CITY OF MERCER ISLAND

June 14, 2018

RE: CAO17-014 (5236 W Mercer Way Critical Area Determination) Request for Information 2

SCALE: AS SHOWN	DATE: 10/10/17
DESIGNED BY: DW	CHECKED BY: JS
JOB NUMBER: 17387	
SHEET: C2.0	
SHEET 6 OF 10

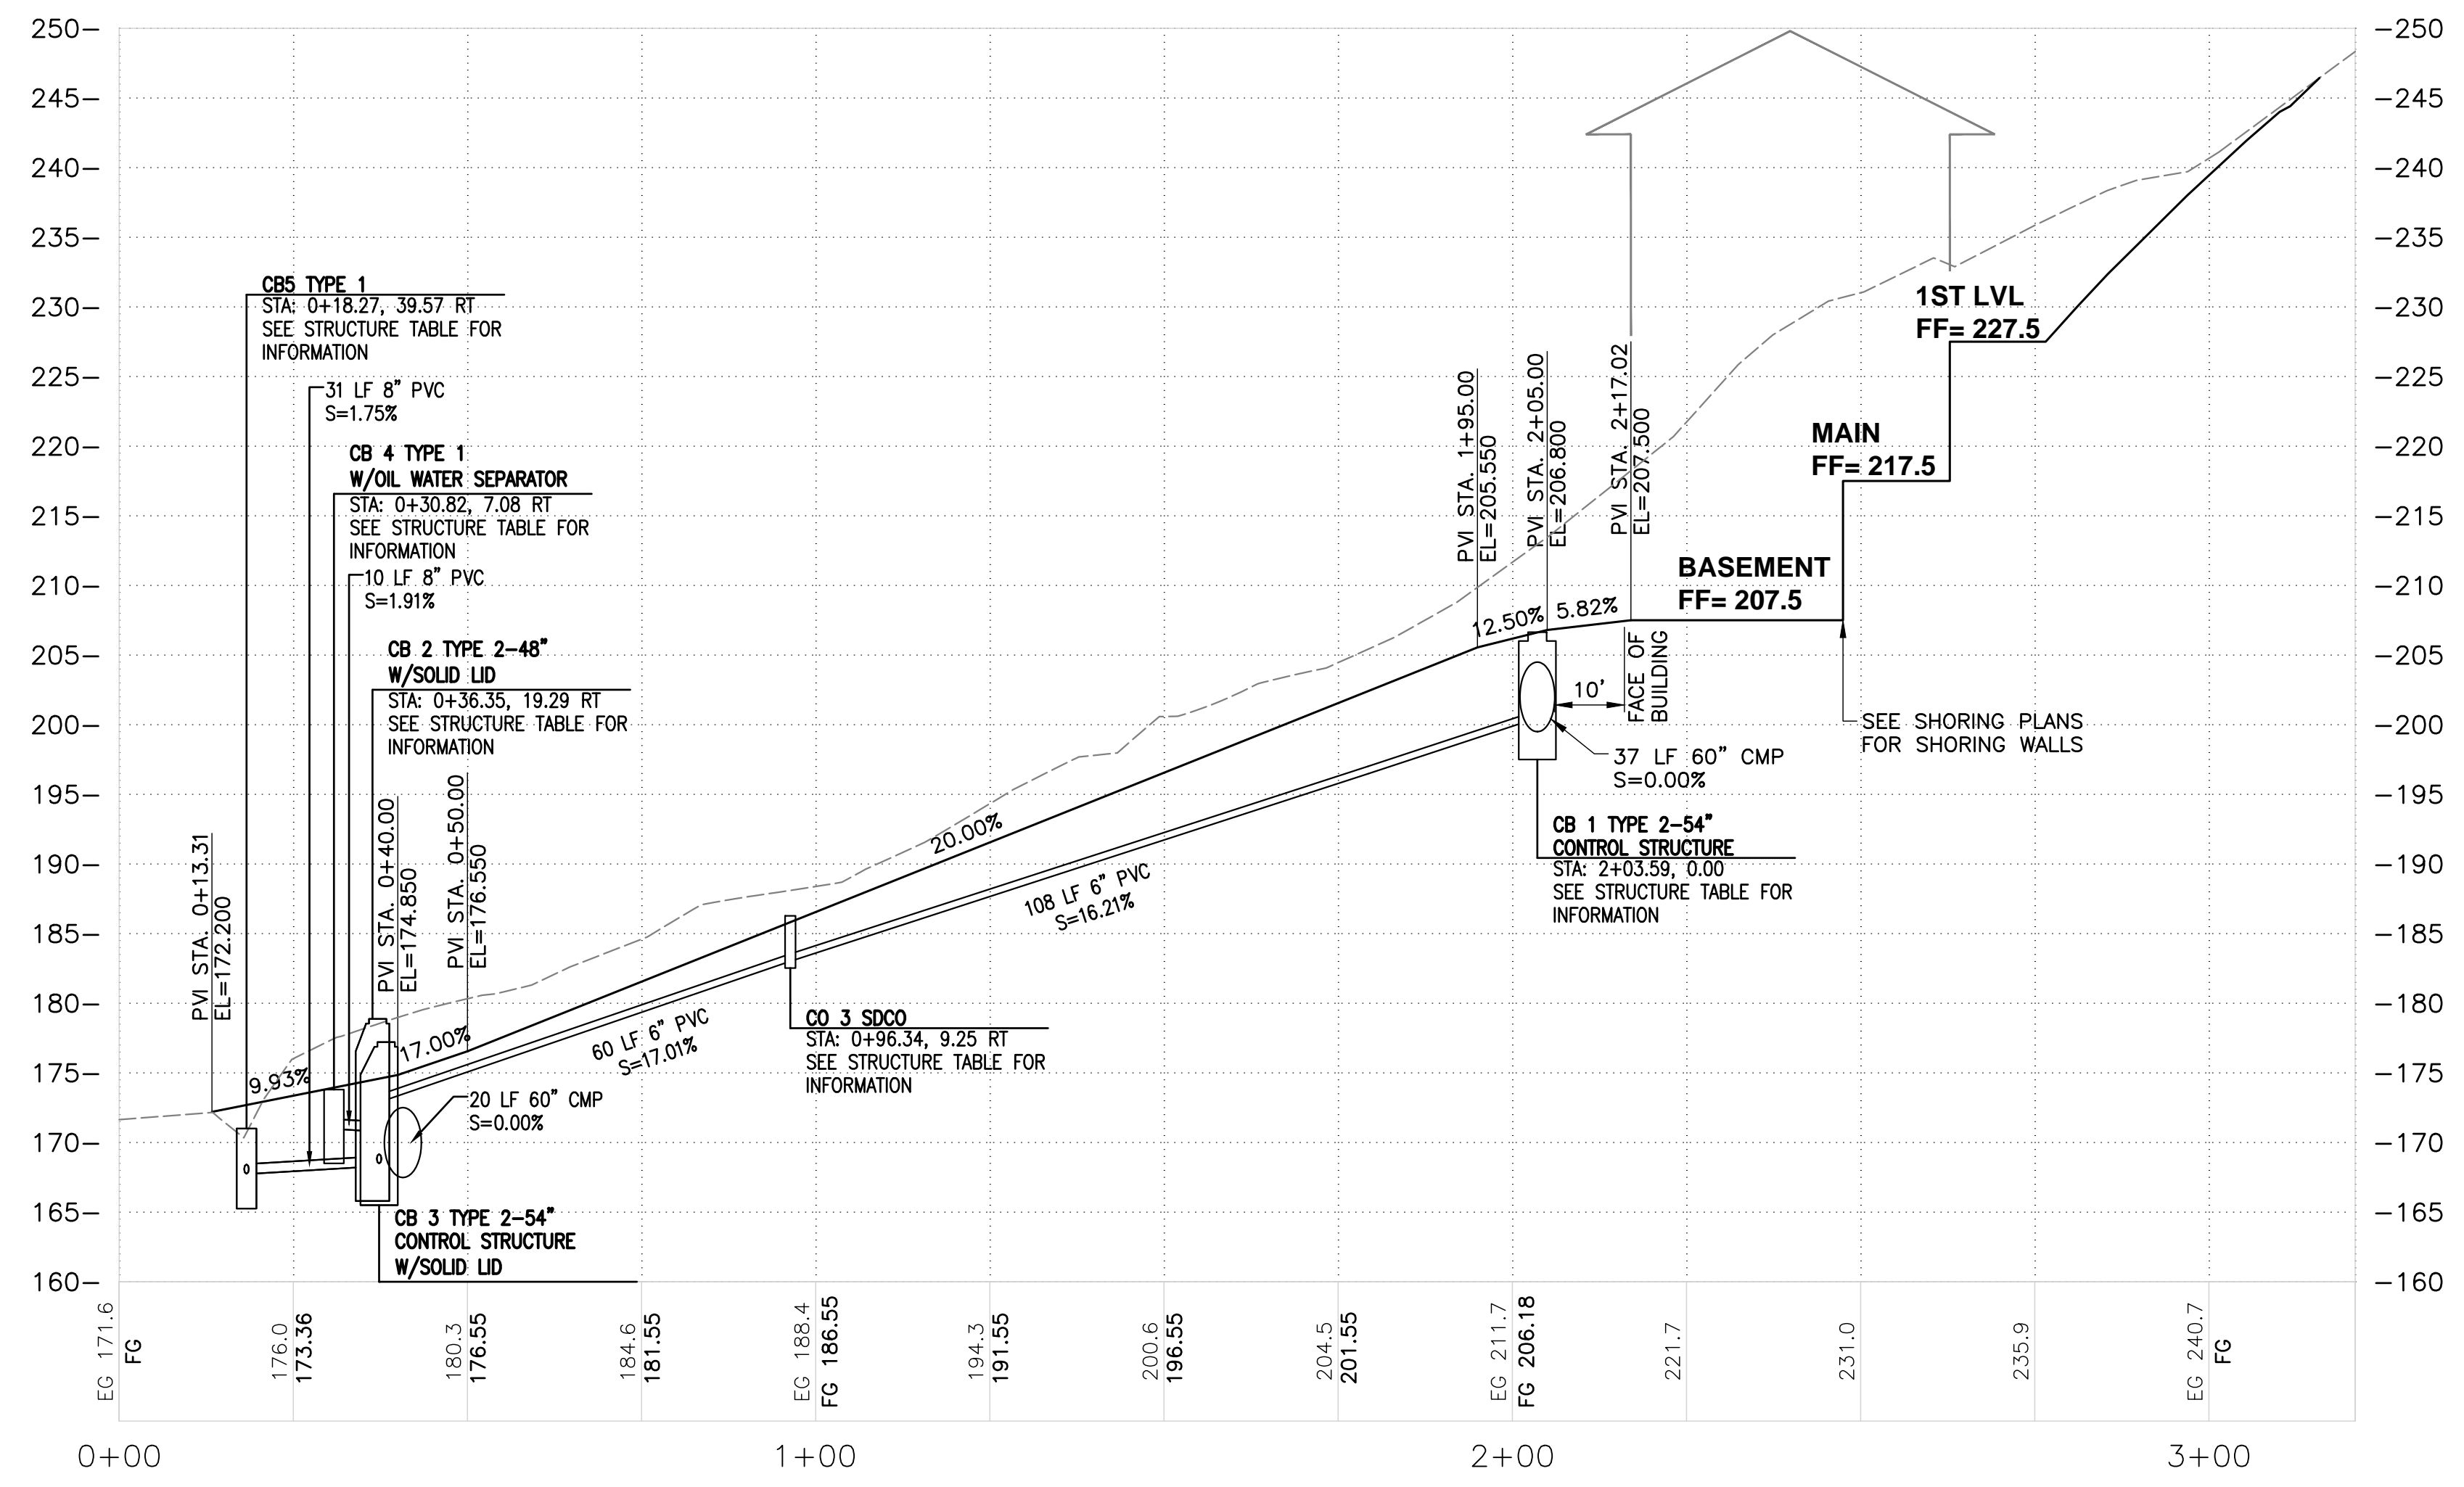
- 4. Please verify height of the retaining wall to the south of the proposed driveway by providing top of wall and bottom of wall elevations at points along the retaining wall.

SHEET INDEX:
W1.0 WETLAND BUFFER MITIGATION PLAN
W2.0 MITIGATION NOTES AND DETAILS

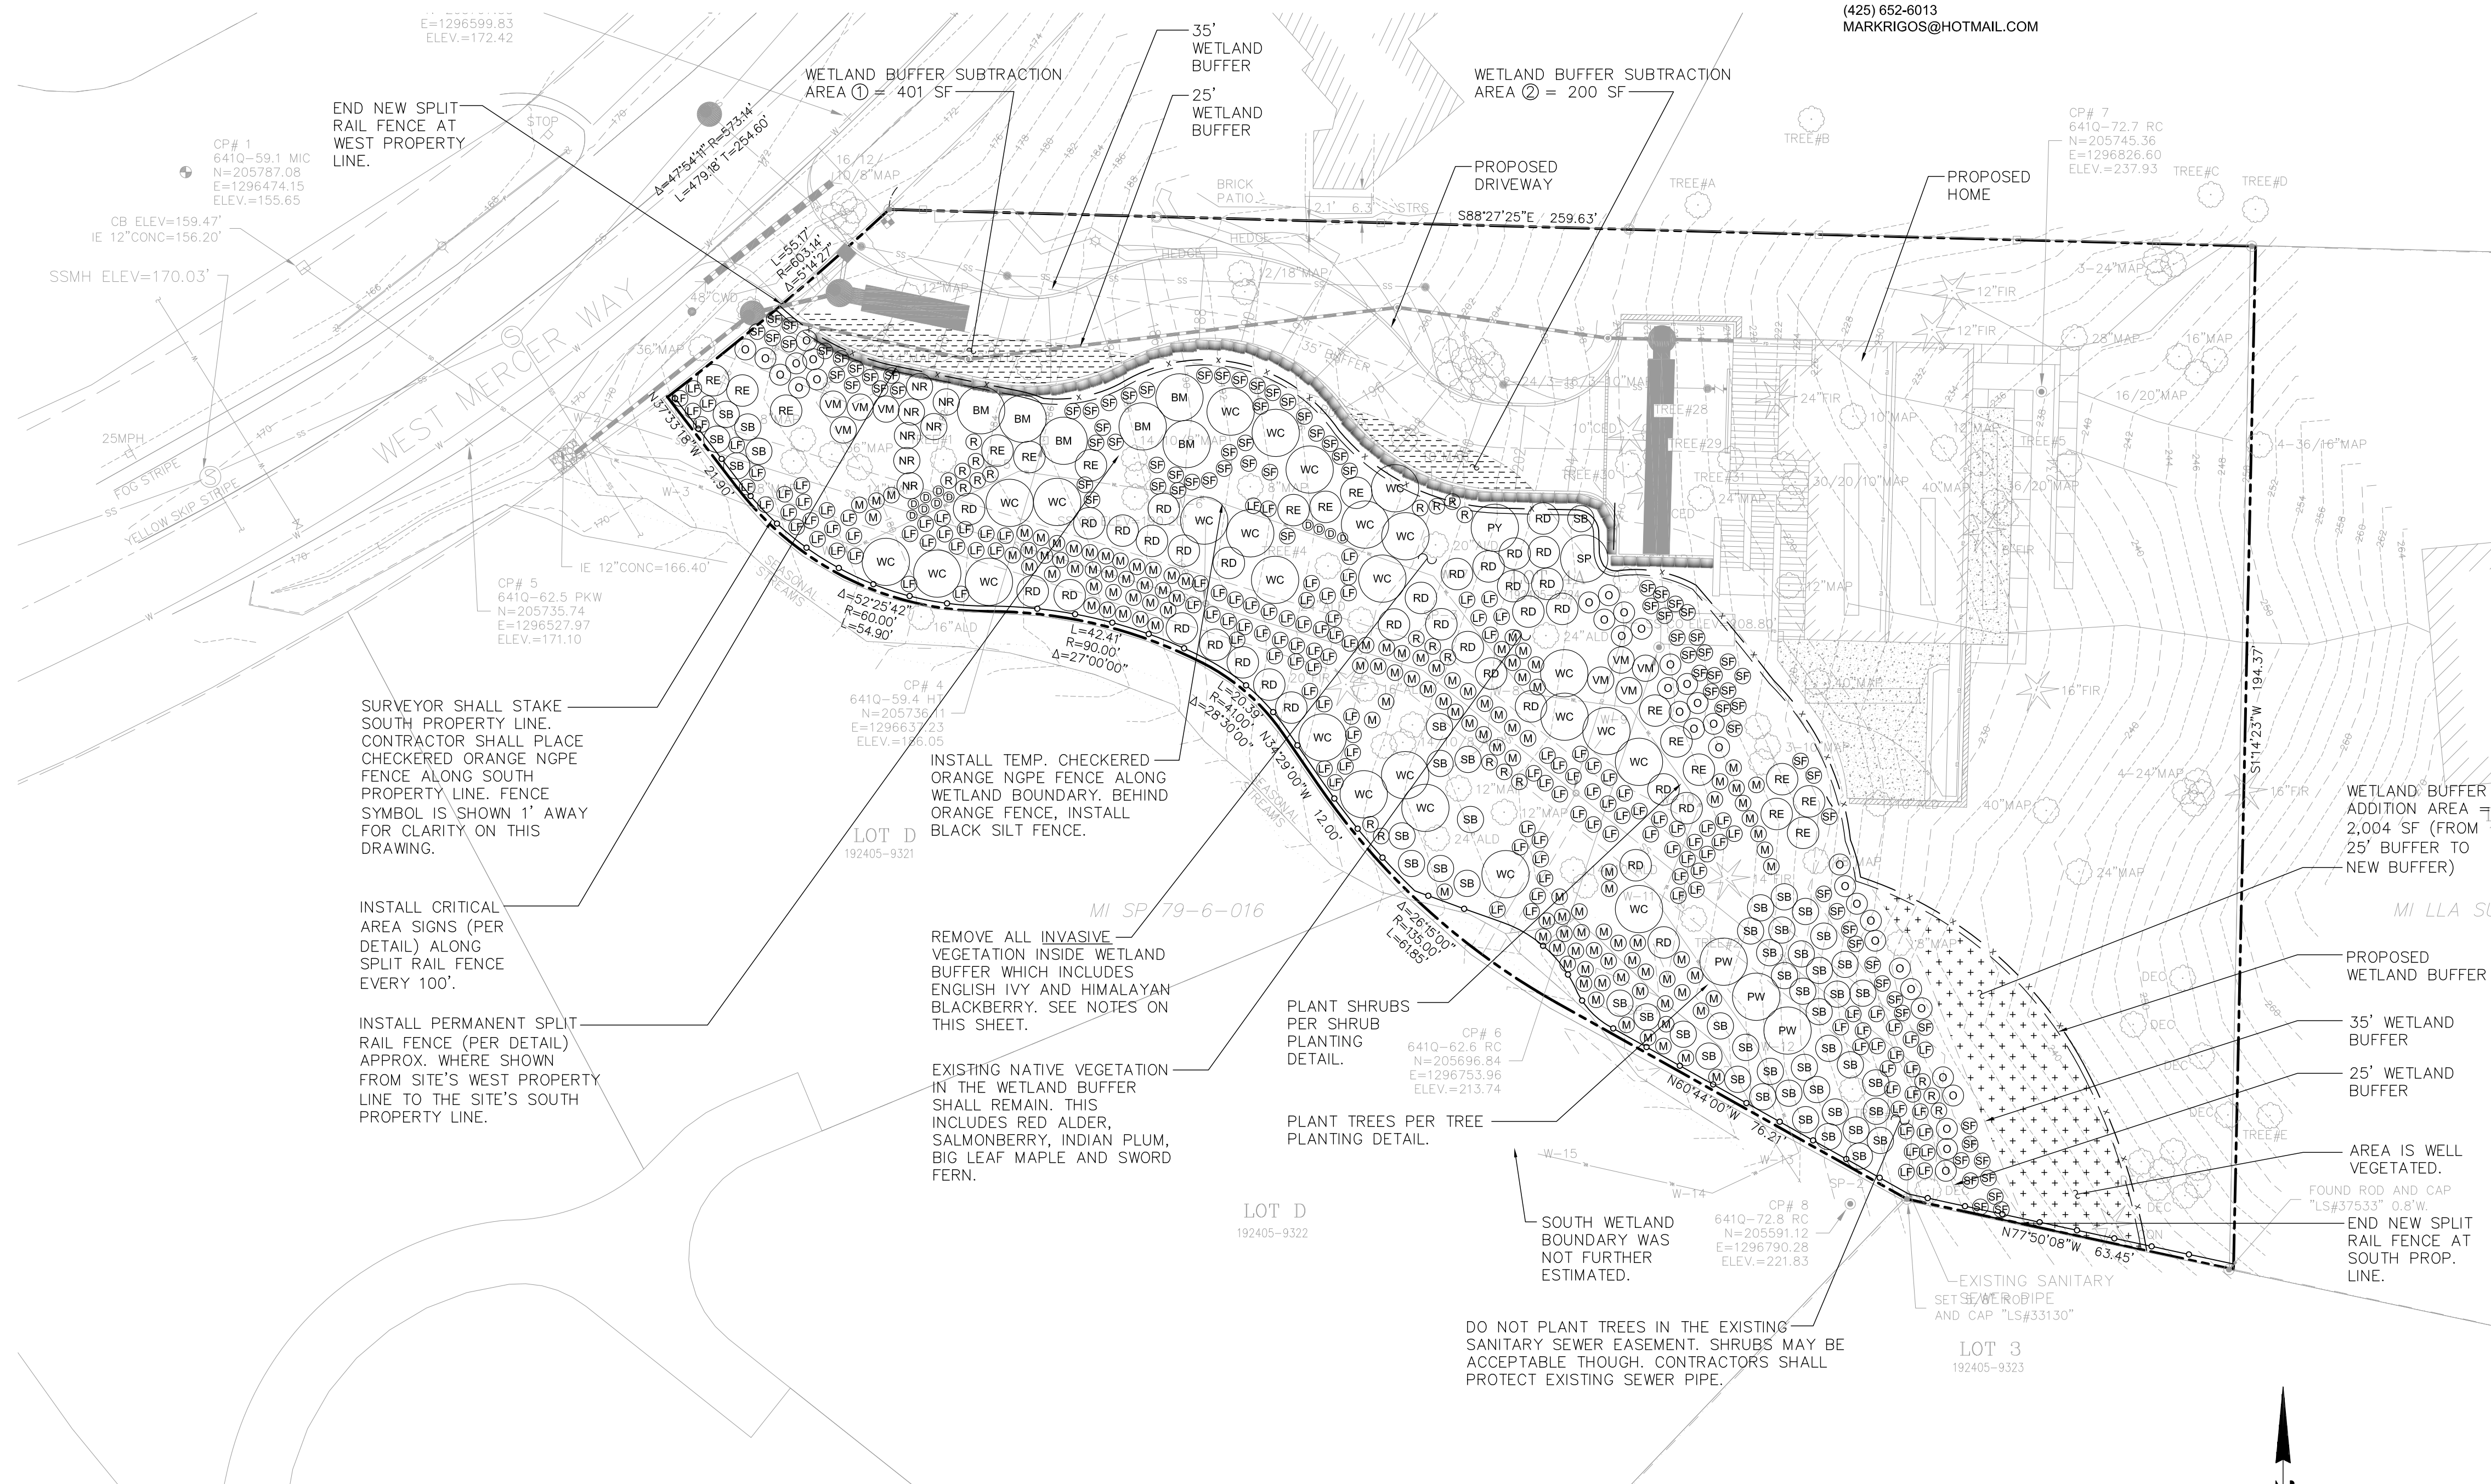
- g. Location of the split-rail fence at the south property line. On Sheet W1.0 the note stating, "End new split rail fence at south prop. Line", appears to point to the orange checkered NDPE fence, when it should be at the edge of the wetland buffer, which includes the wetland buffer addition area.

- h. Extra items in the legend. The concurrency letter notes items that are included in the legend, but not shown on the plan, and which therefore should be removed. This comment was not address in the revised plan.

The NGPE fence location near the south property line on Sheet W1.0 has been revised.

The legend has been updated on Sheet W1.0.

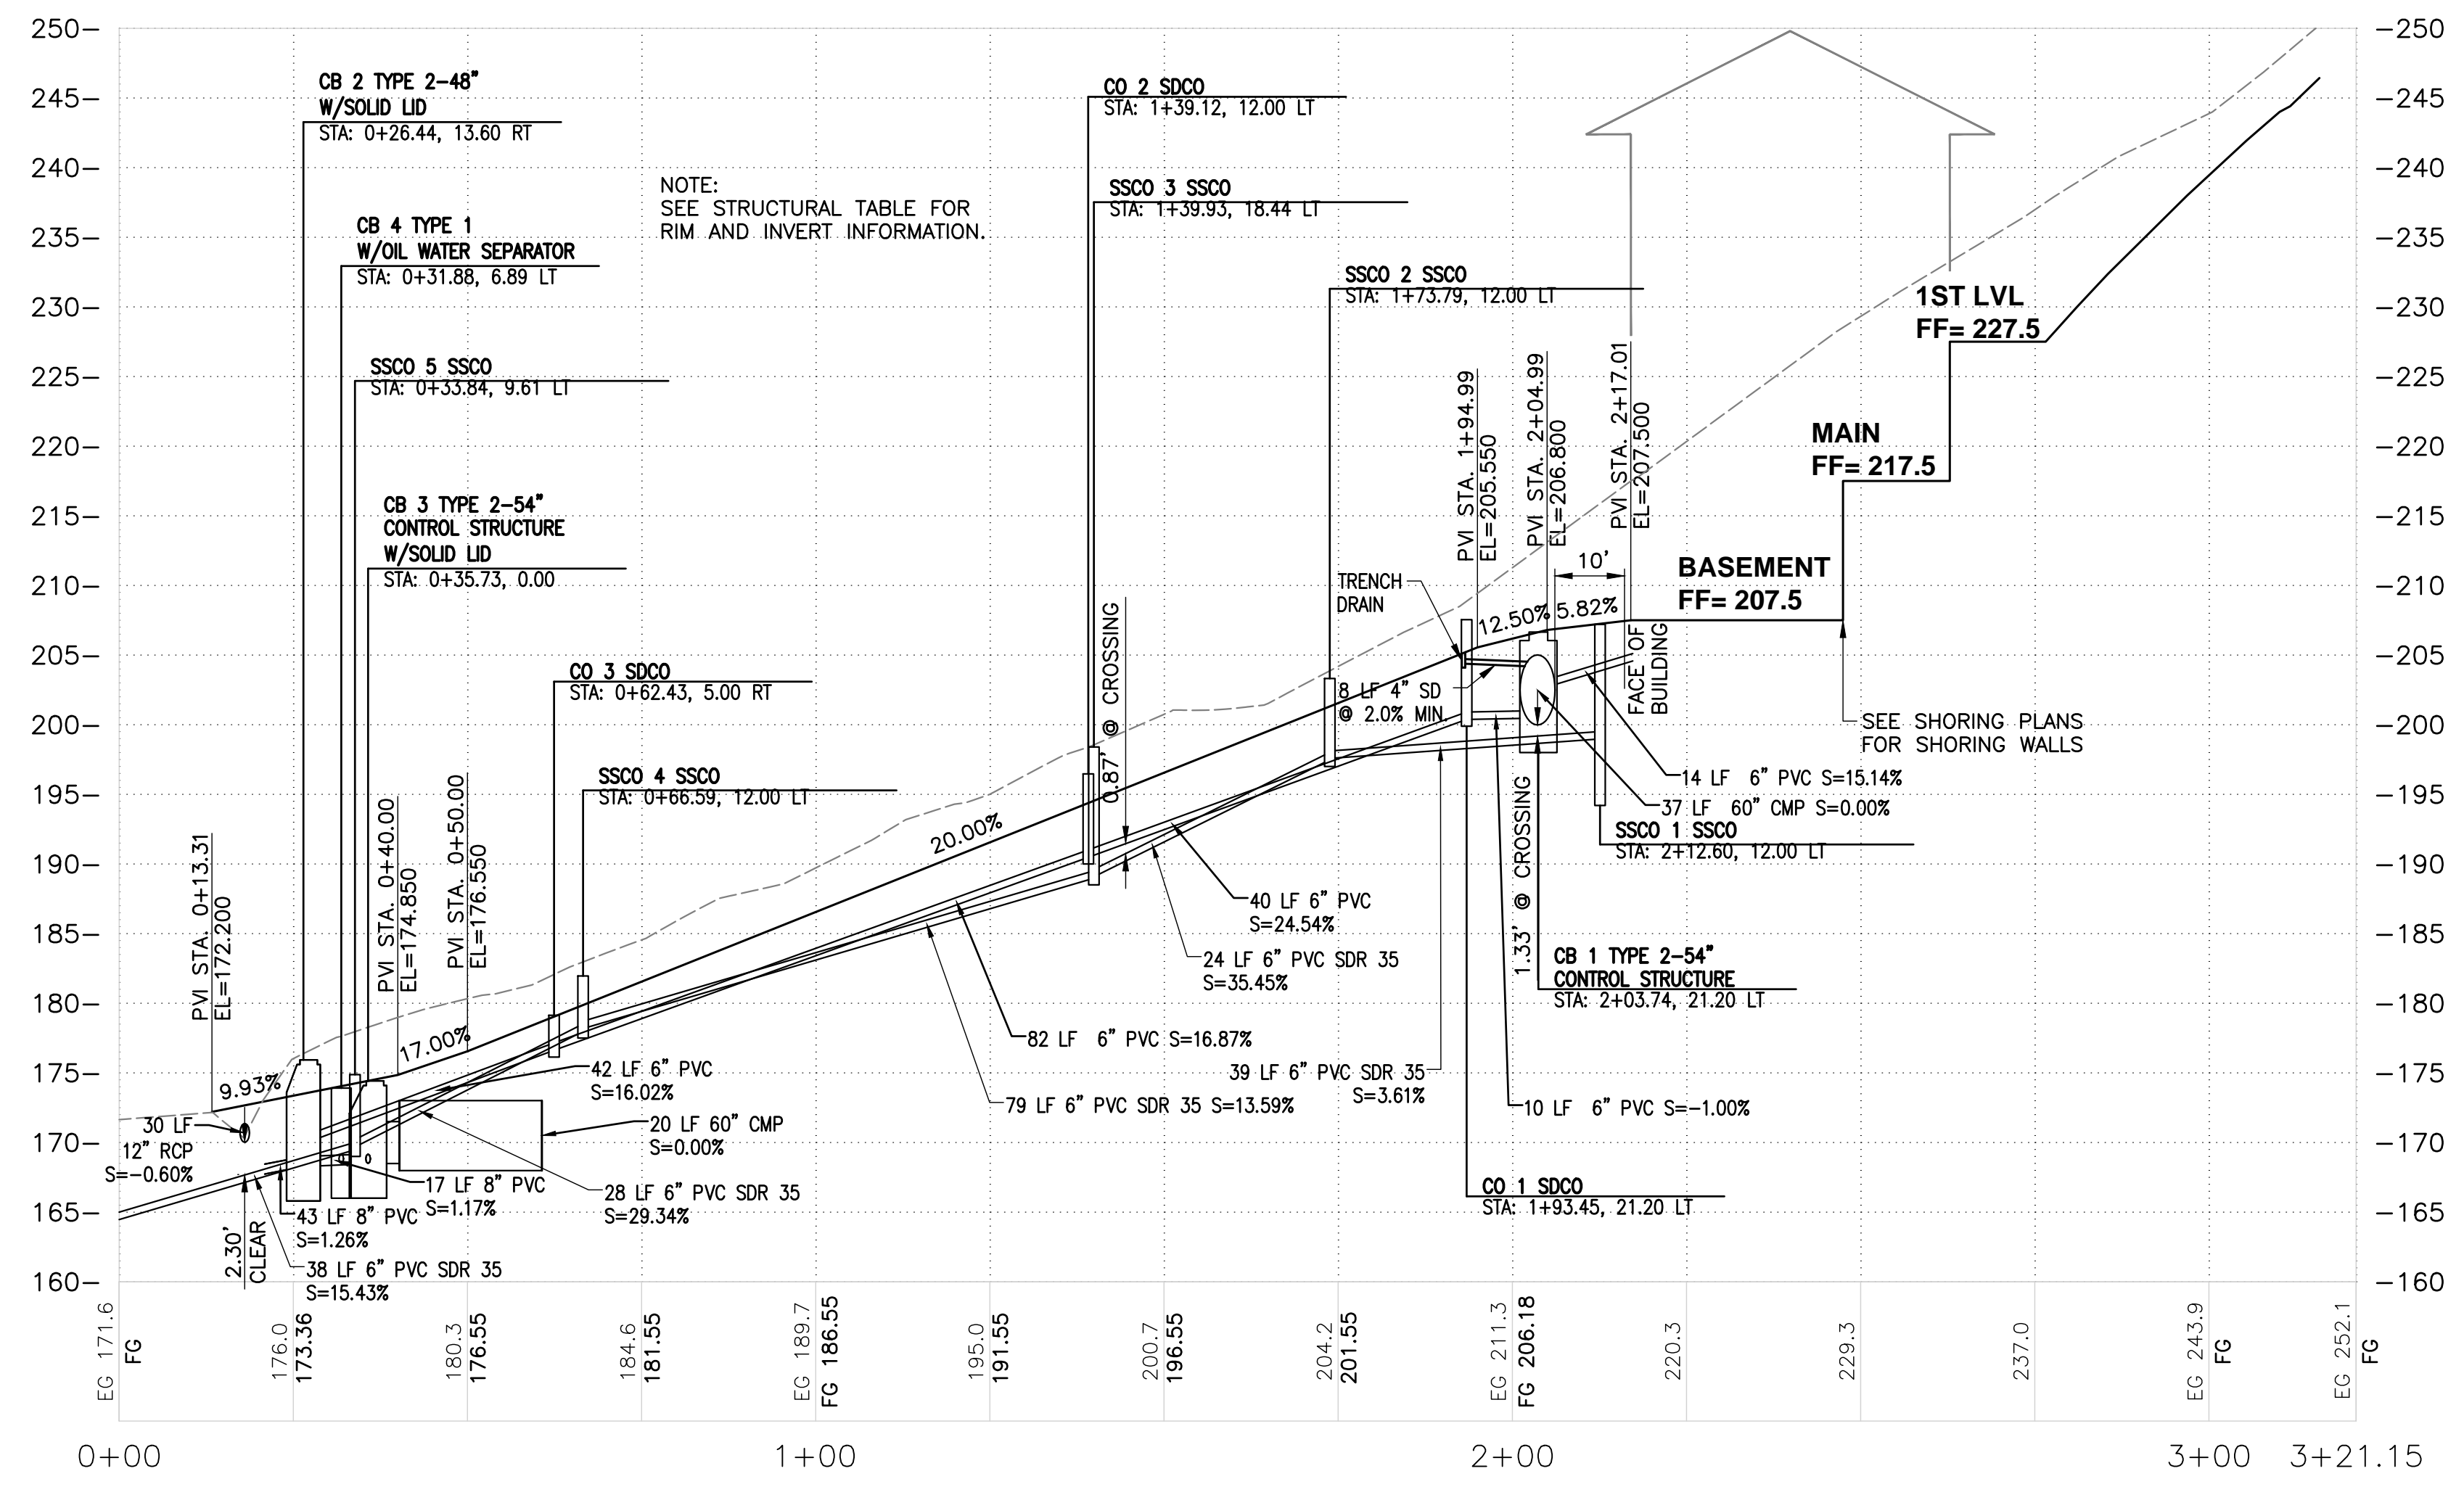
4. Please verify height of the retaining wall to the south of the proposed driveway by providing top of wall and bottom of wall elevations at points along the retaining wall.

Wall heights provided along wall. See civil plans, sheet C2.0.
